The Secretary  
NSW Planning, Industry & Environment

18 June 2021

I refer to the Department's below email of 10 June 2021 regarding the public exhibition of the Environmental Impact Statement (EIS) for State Significant Development SSD-9887 West Nowra Resource Recovery Park Stage 2 for 'Construction and operation of stage 2 of the West Nowra Resource Recovery Park, comprising a resource recovery facility for treatment of up to 130,000 tonnes per year of mixed municipal waste' at Flatrock Road, off Yalwal Road, West Nowra (Lot 342 DP 257515) in the Shoalhaven City Local Government Area. Submissions need to be made to the Department by 12 July 2021.

Figure 1-1

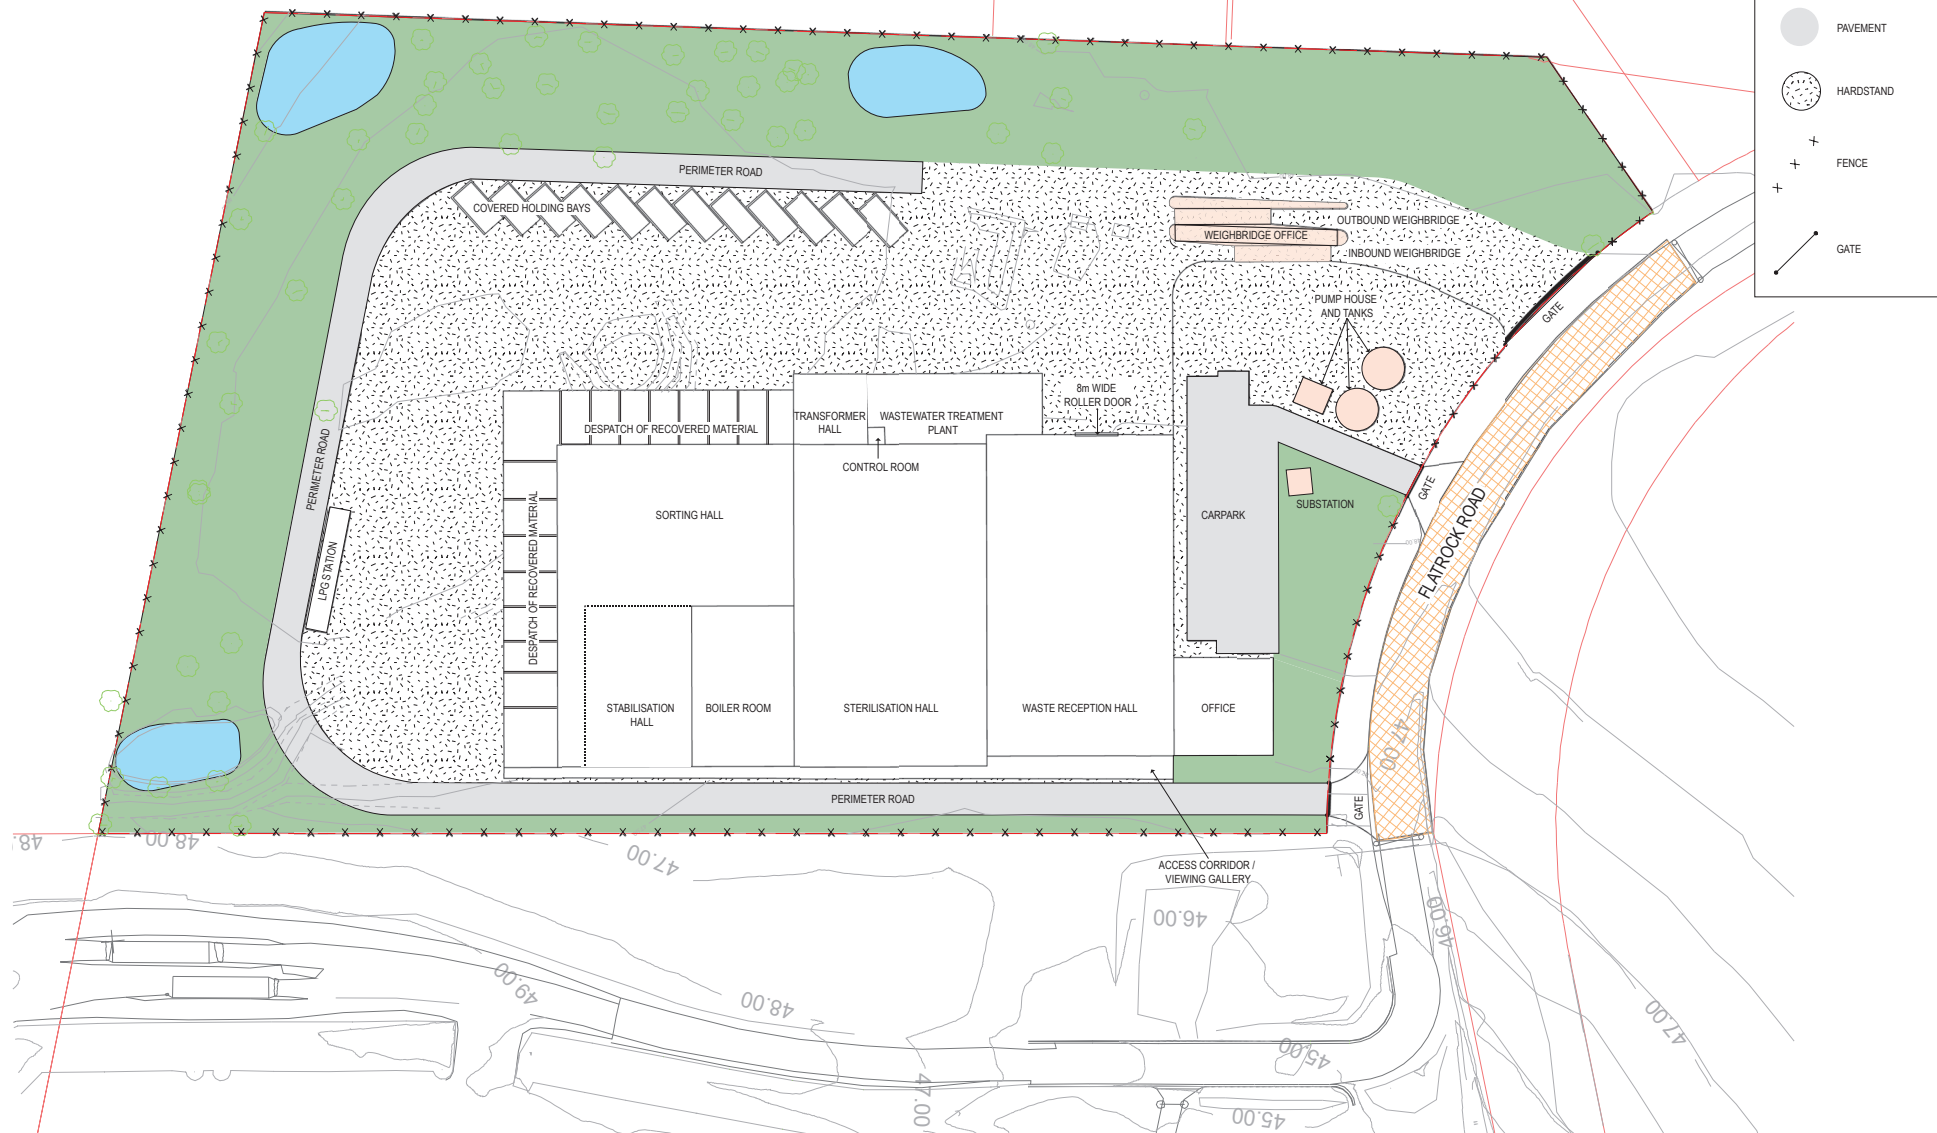
Endeavour Energy has noted the Site Plan does not show the location of the poles and overhead power lines to the road frontage. The following is an extract of the Site Plan on which the approximate location of the poles is shown from an overlay of the site plan from Endeavour Energy's G/Net master facility model which shows two poles located within the gates.

For public / road safety and to reduce the likelihood / protect electricity infrastructure from vehicle impact, Endeavour Energy's recommendation that the minimum separation distance of driveways from:

Endeavour Energy's preference is to have the maximum reasonably possible separation distances from driveways and its electricity infrastructure. Failing the foregoing, an asset relocation may be the only option remaining – which in this instance may be the case.
